Your Ref: OWPC24425
Our Ref: FP/170/19/HH 07-08-2019
Please ask for:
Finlay Gardner

Erection of sunrooms including the demolition of existing sunrooms.

6 & 8 Gorse Avenue Felpham

Title
6 & 8 GORSE AVENUE
CONSERVATORY/SUN ROOM
PROPOSED PLAN AND ELEVATIONS

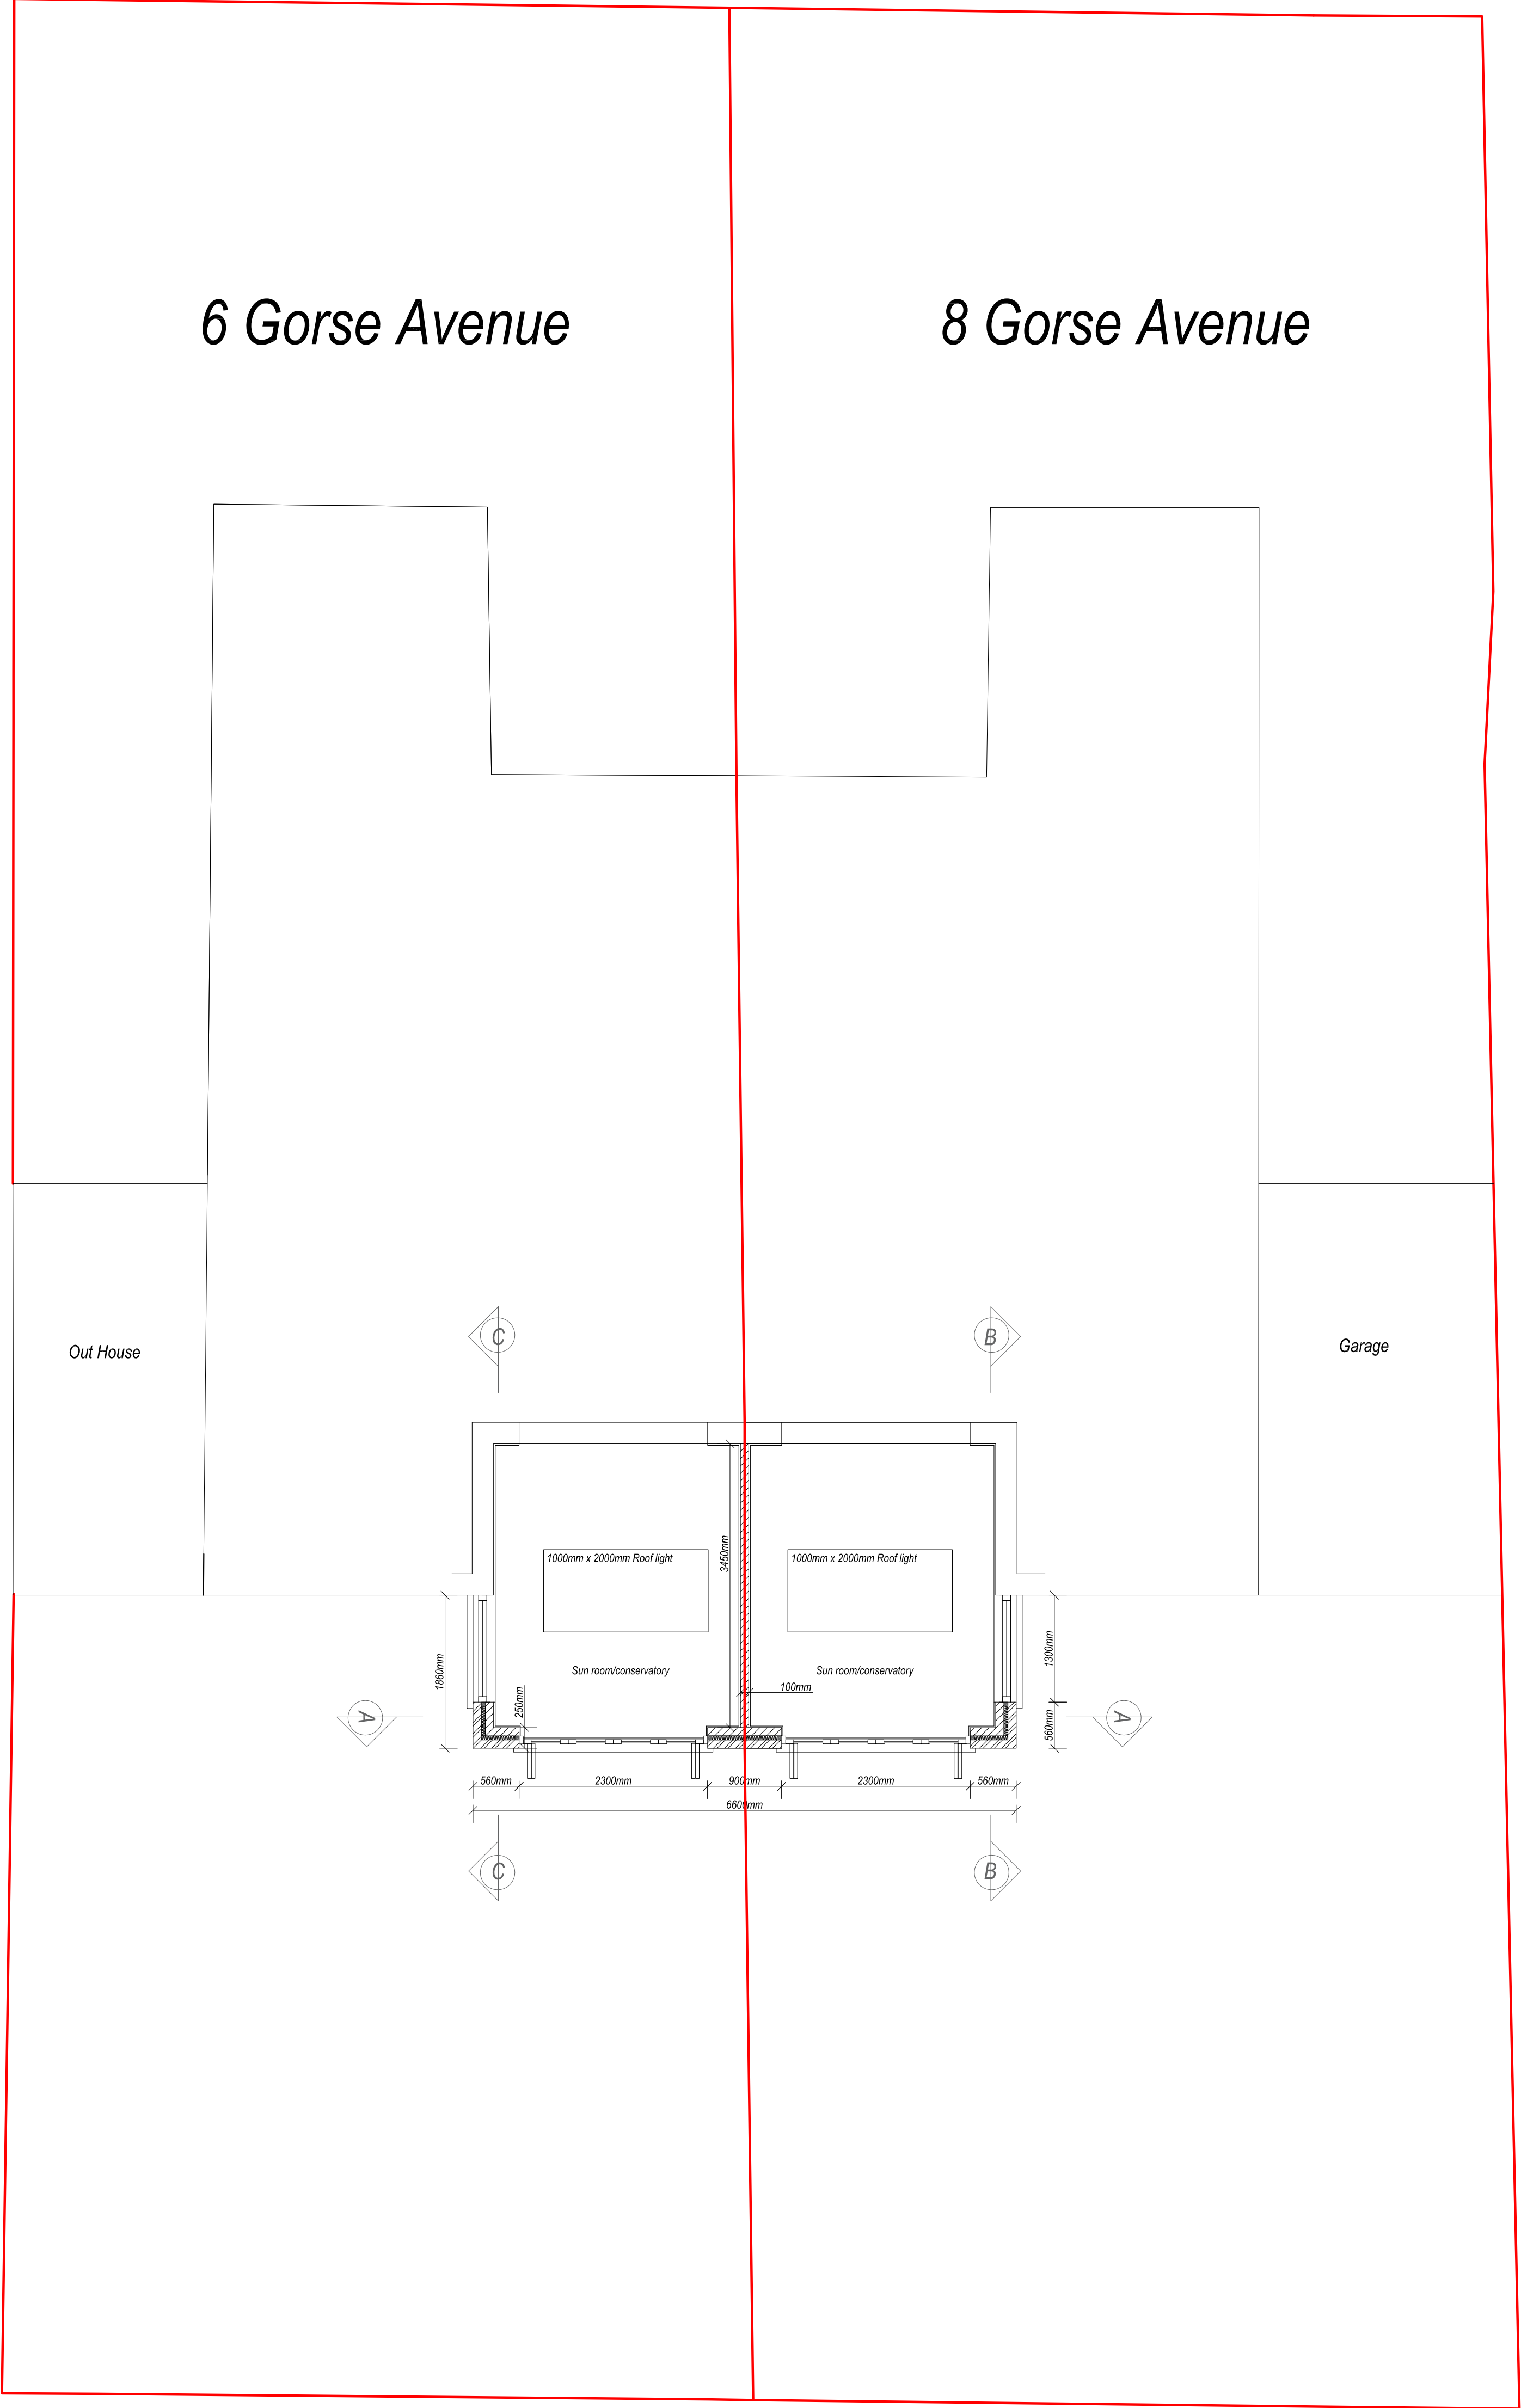
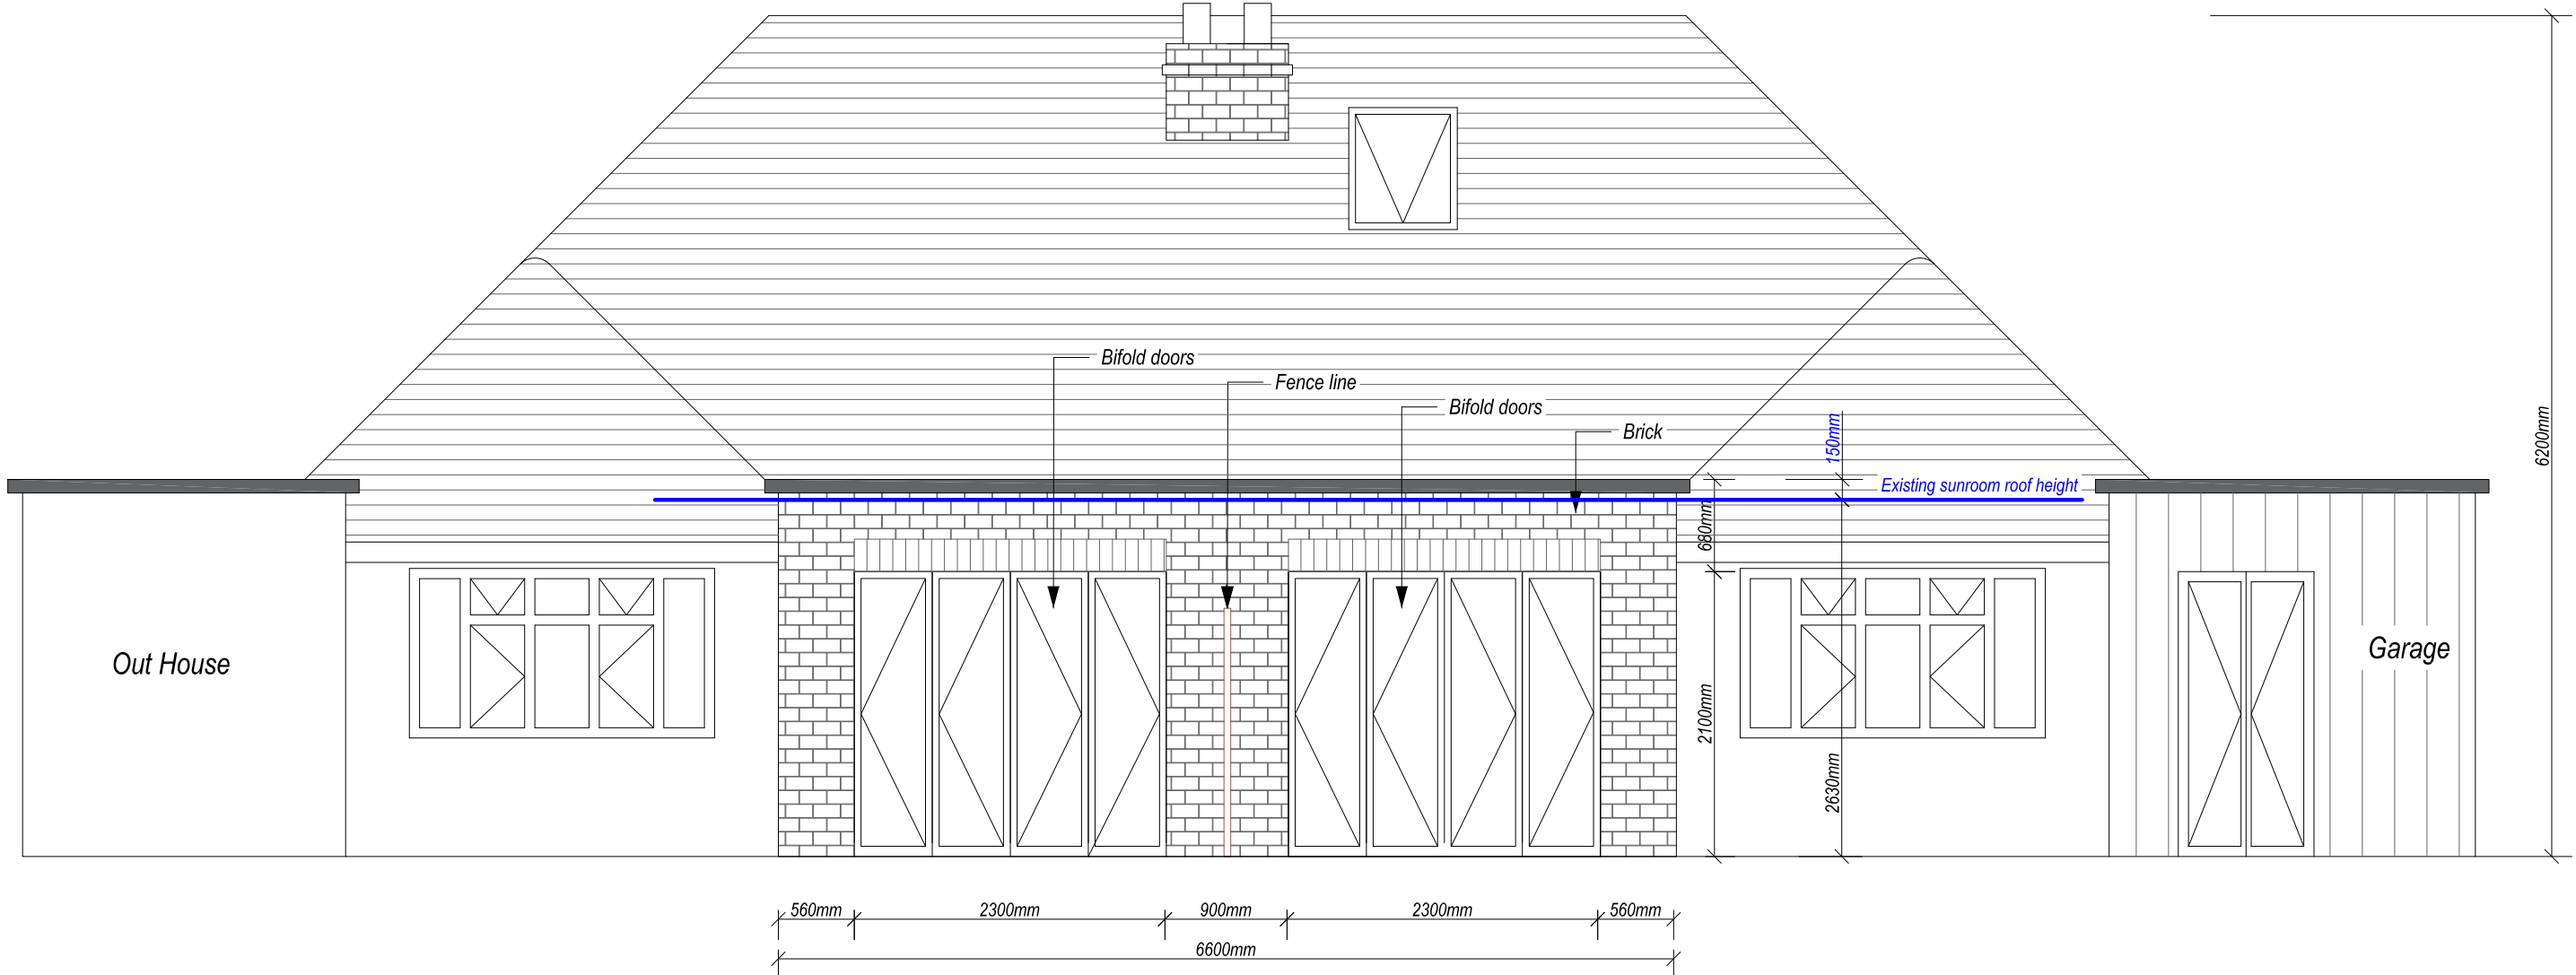
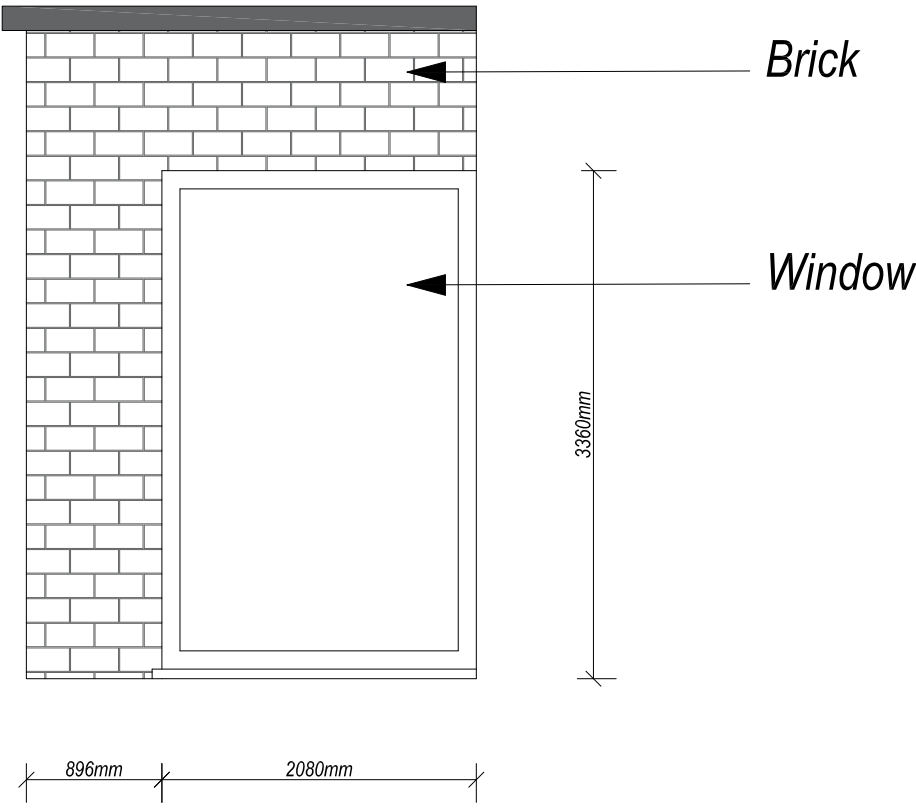
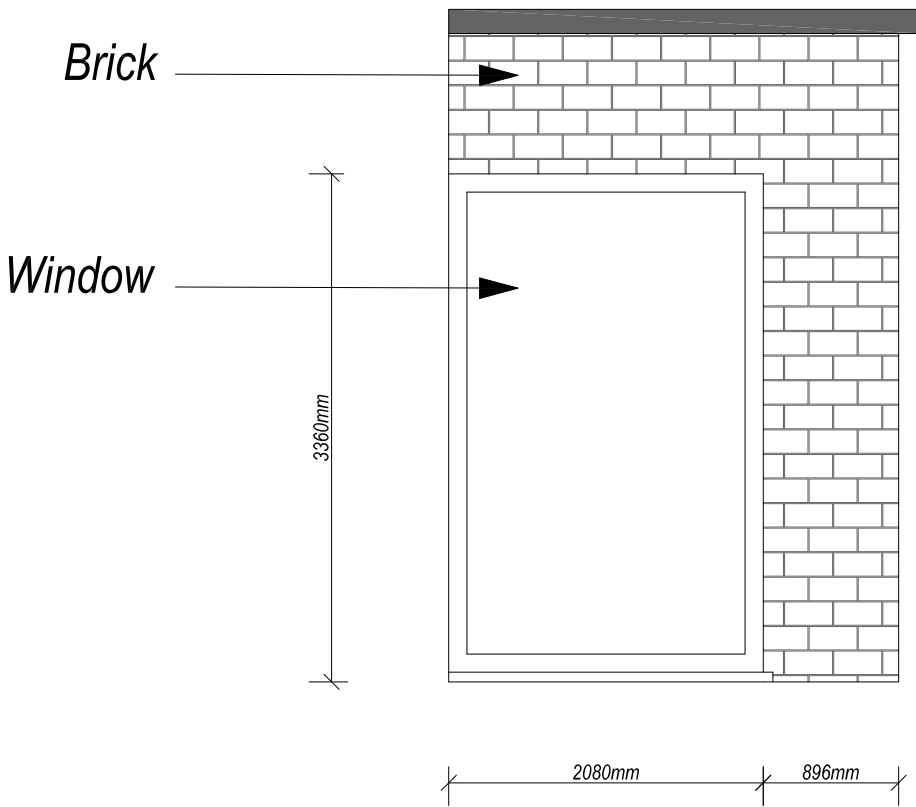
- 1. The applications are misleading and suggest a like-for-like renewal of sunrooms - there are not renewals, they are extensions.*
- 2. The extensions have significantly increased the footprint of the buildings - the rear boundary is closer to the neighbouring properties.*

- 3. The height of both extensions extends above the eaves height of the original buildings and neighbouring properties now suffer from a loss of privacy and from intrusive light pollution*

- 4. The extensions are not sympathetic with the design and style of the original Art Deco buildings - the grey brickwork now resembles a modern public toilet block!*
